**MECKLENBURG COUNTY**  
**Land Use & Environmental Services Agency**

**MEMORANDUM**

Subject: Initial Rezoning Petition Comments

**2021-018: North Poplar Development Partners**

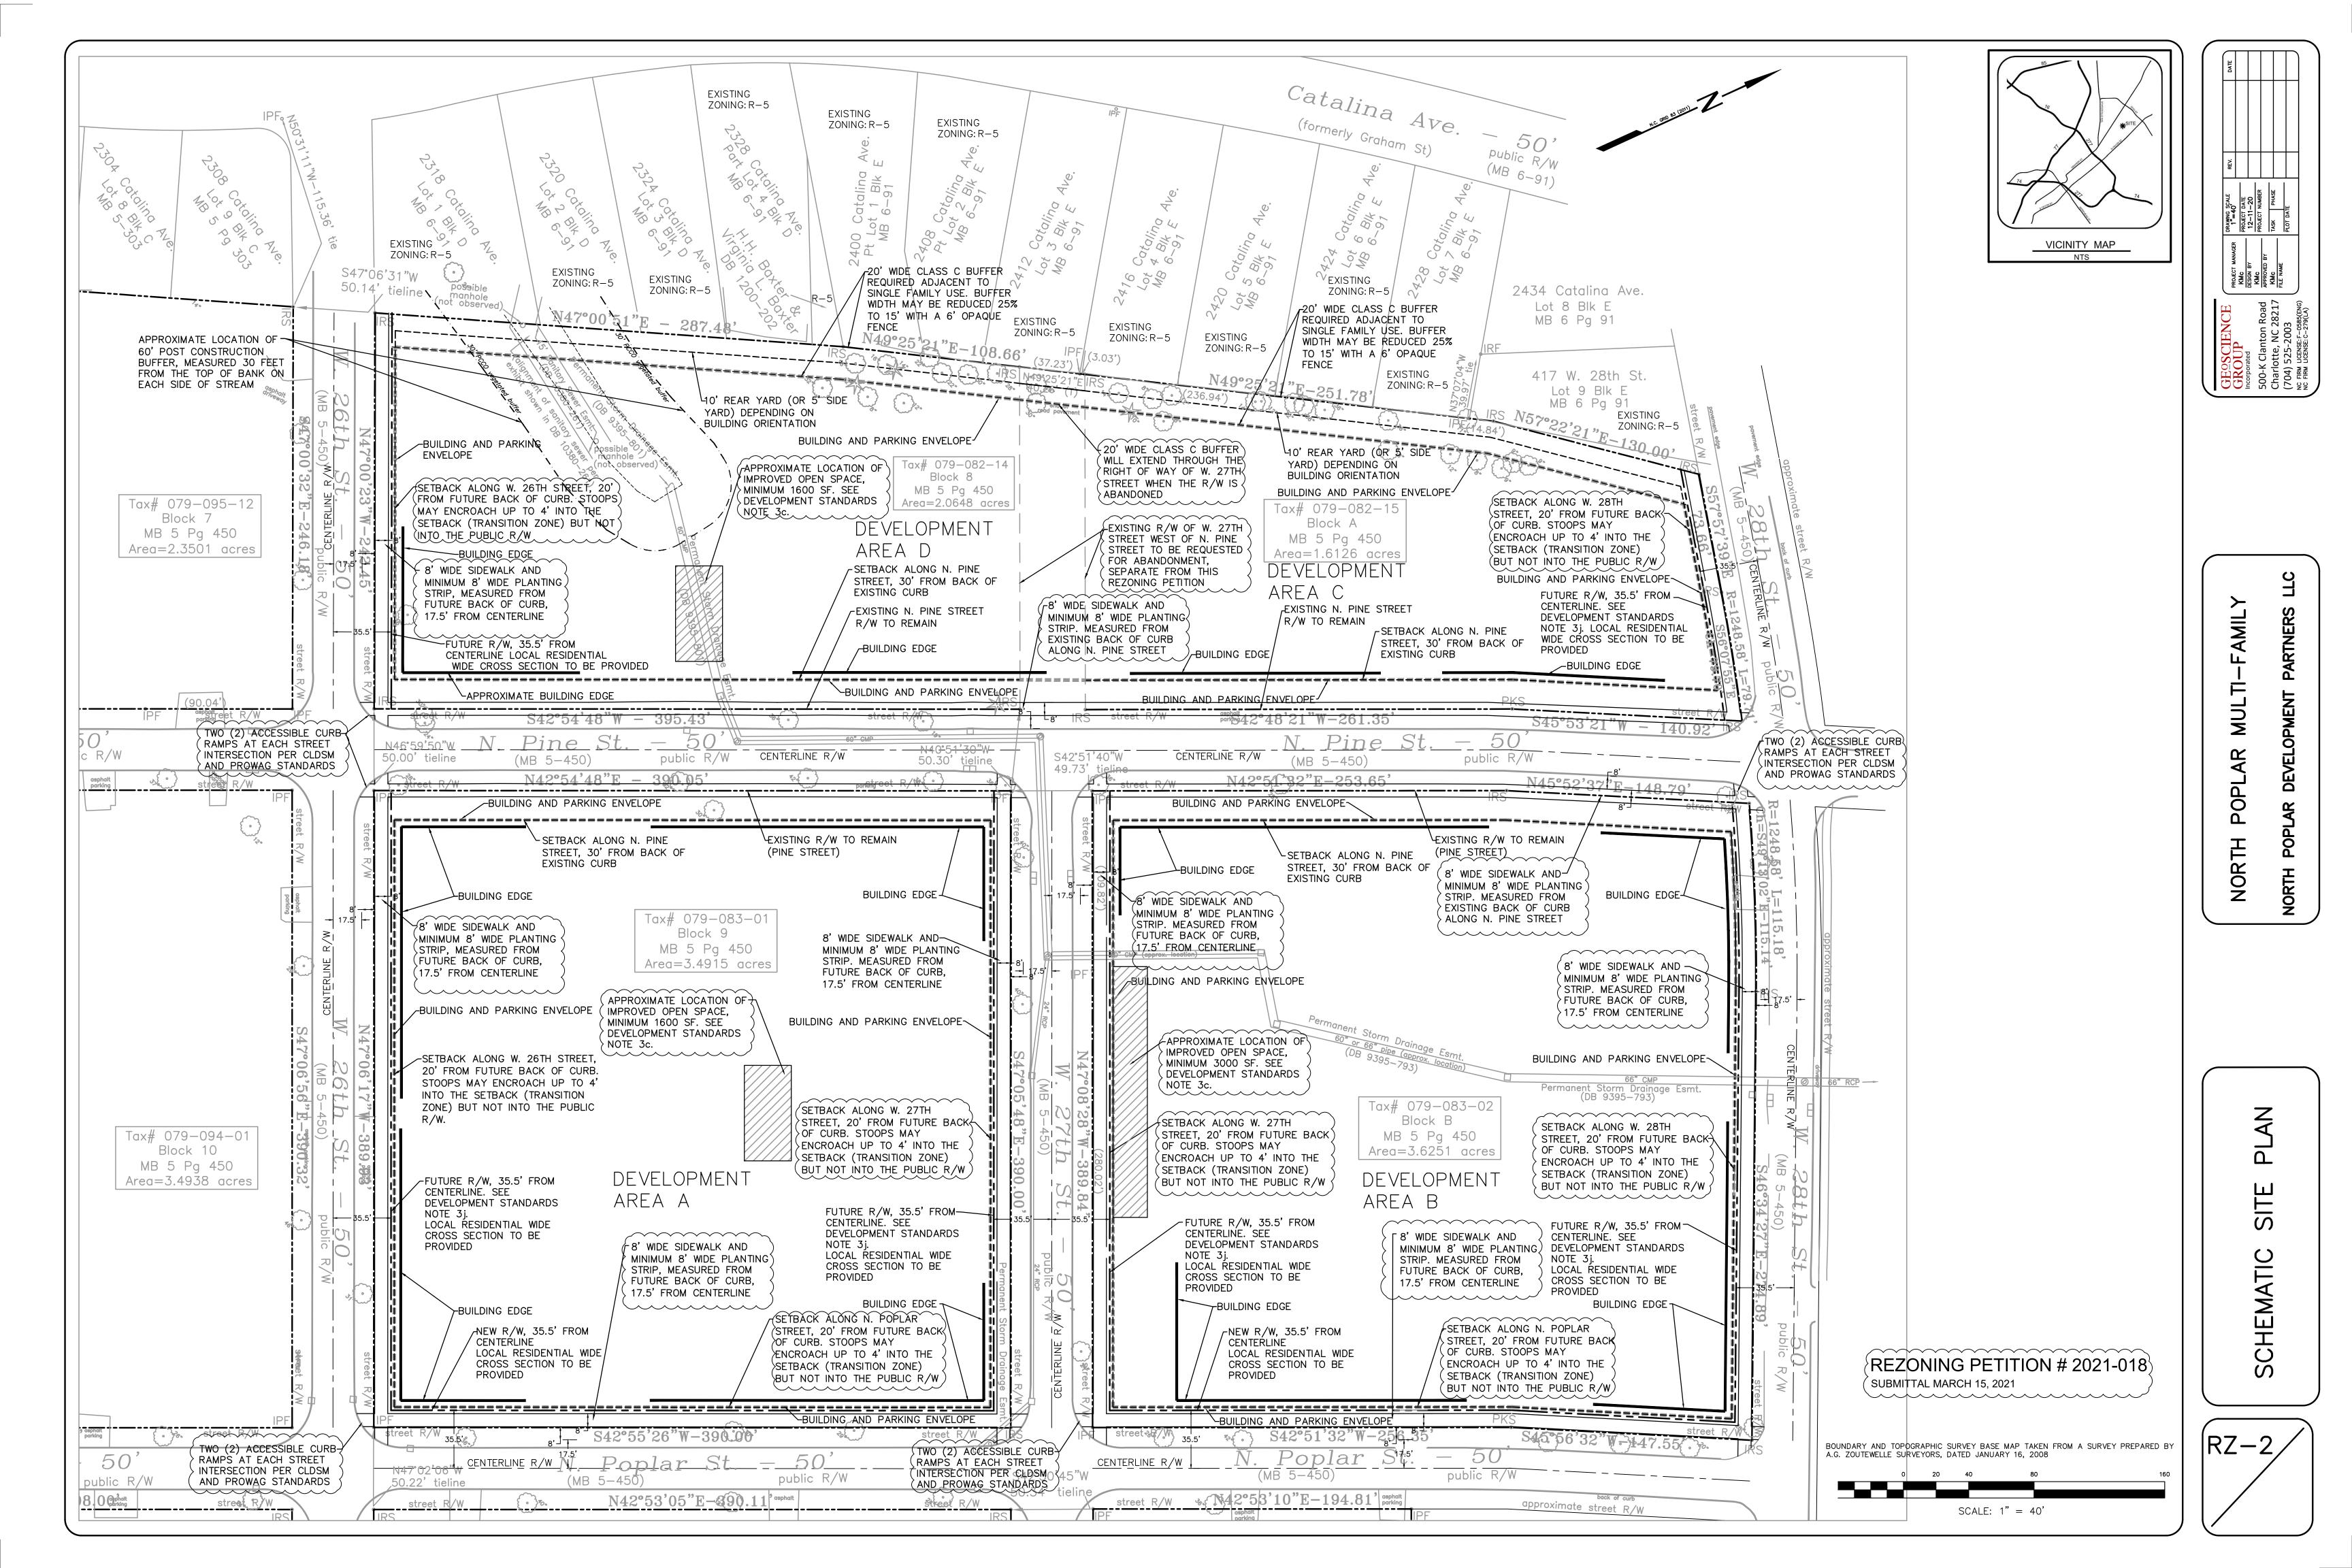
Groundwater & Wastewater Services records indicate a registered septic system exists on parcel 079-082-14. No regulations govern the abandonment of septic systems; however, GWS does recommend that septic tanks be pumped by a NC Licensed Septic Hauler to remove any residual contents and then crushed and backfilled. This recommendation is made because improperly abandoned septic tanks may not be able to support the weight of vehicular traffic, structural foundations or people posing a safety hazard.
